From: Richard Martin
Sent: 19 October 2017 14:43
To: Zac Denton
Cc: Juan Baeza
Subject: FW: R/1/17/T
Attachments: BROOKENBEE CLOSE.R.1.17.T.pdf; COWDRAY DRIVE.R.1.17.T.pdf;
HUTCHISON.SUMMERLEY.FOXES.R.1.17.T.pdf; WATERSMEAD DRIVE.R.1.17.T.pdf

Bernie has provided approval for as much as he can, as anticipated some further work/specific details are required from the applicant. Hopefully this is clearly set out in the attached.

WATERSMEAD DRIVE

PARKLANDS / COWDRAY DRIVE

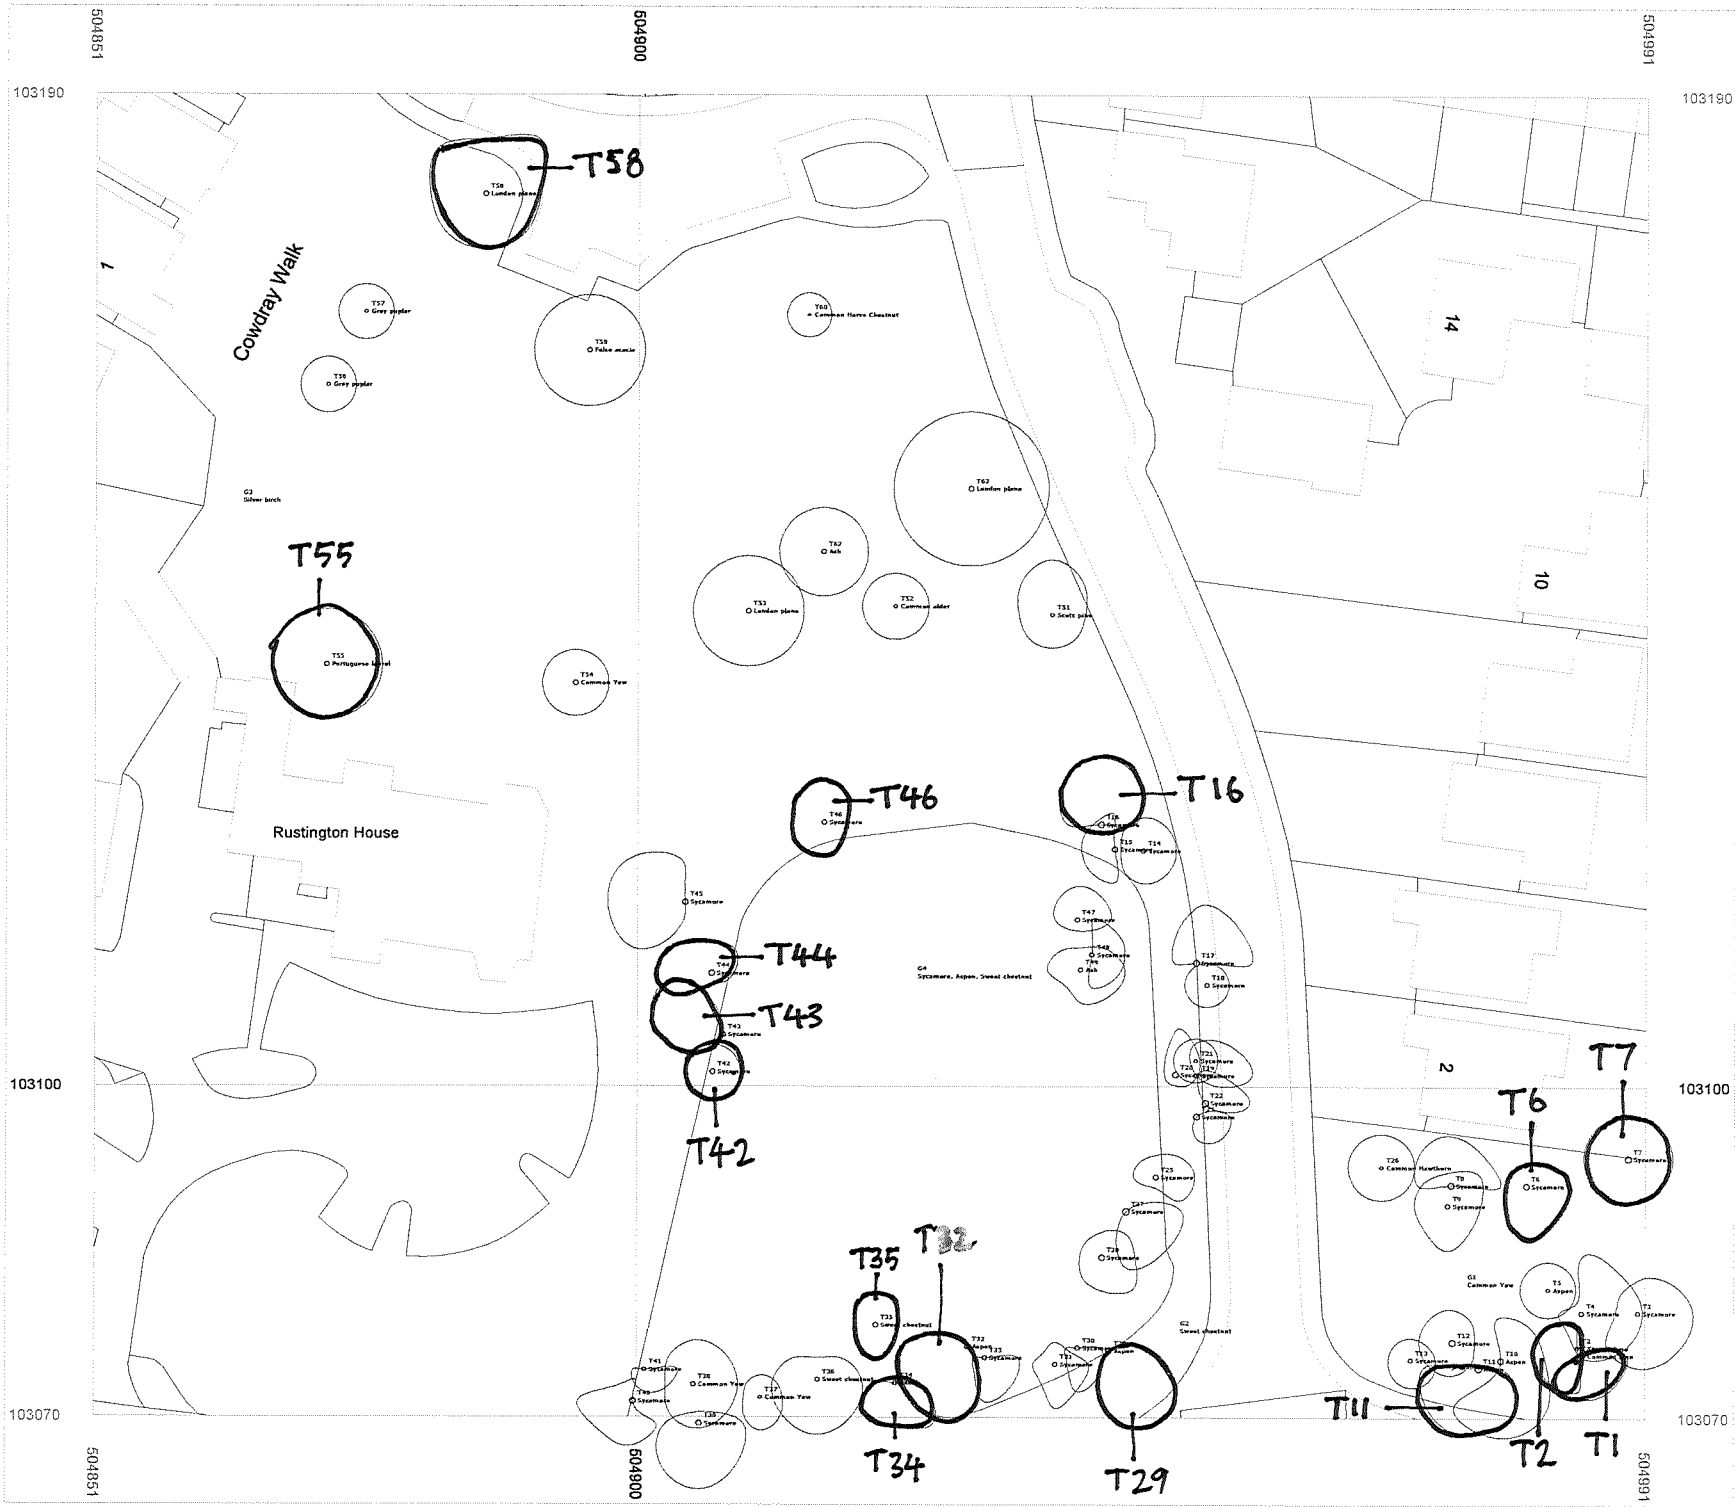
No.	Species	Work Applied For	Works Approved	Works Refused	Advised Works For Re-Submission
T1	Lime	Remove epicormic growth	Remove basal suckers	-	-
T2	Lime	Remove epicormic growth	Remove basal suckers	-	-
T6	Sycamore	Reduce faulted limbs/stems squirrel damaged	-	-	Need a climbing inspection report with photographs to highlight the degree of damage – plus need more specific details i.e. how many branches in total would be reduced? How much would be taken off the ends of each branch? Otherwise we would be agreeing to this blind and the tree could be devastated and its amenity value undermined by the amount of branch loss?
T7	Sycamore	Reduce faulted limbs/stems squirrel damaged	-	-	Need a climbing inspection report with photographs to highlight the degree of damage – plus need more specific details i.e. how many branches in total would be reduced? How much would be taken off the ends of each branch? Otherwise we would be agreeing to this blind and the tree could be devastated and its amenity value undermined by the amount of branch loss?

T11	Aspen	Reduce faulted limbs/stems rubbing branches. Reduce crown by 3m away from light.	Reduce crown by 3m away from light.	Reduce faulted limbs/stems rubbing branches	Need a climbing inspection report with photographs to highlight the degree of damage – plus need more specific details i.e. if its rubbing branches then how many are there and which of each pairing will they be removing. Otherwise we would be agreeing to this blind and the tree could be devastated and its amenity value undermined by the amount of branch loss?
T16	Sycamore	Reduce faulted limbs/stems crossing branches.	-	Reduce faulted limbs/stems crossing branches.	Need a climbing inspection report with photographs to highlight the degree of damage – plus need more specific details i.e. if its crossing branches then how many are there and which of each pairing will they be removing. Otherwise we would be agreeing to this blind and the tree could be devastated and its amenity value undermined by the amount of branch loss?

T29	Aspen	Reduce crown - laterals 3m height 2m	Reduce crown - laterals 3m height 2m	-	-
T32	Aspen	Reduce crown – reduce southern crown by 2m to 3m	Reduce crown – reduce southern crown by 2m to 3m	-	-
T34	Beech	Reduce faulted limbs/stems remove squirrel damaged lateral branches	-	Reduce faulted limbs/stems remove squirrel damaged lateral branches	Need a climbing inspection report with photographs to highlight the degree of damage – plus need more specific details i.e. if its squirrel damage alone then they need to state how many branches are affected. Otherwise we would be agreeing to this blind and the tree could be devastated and its amenity value undermined by the amount of branch loss?
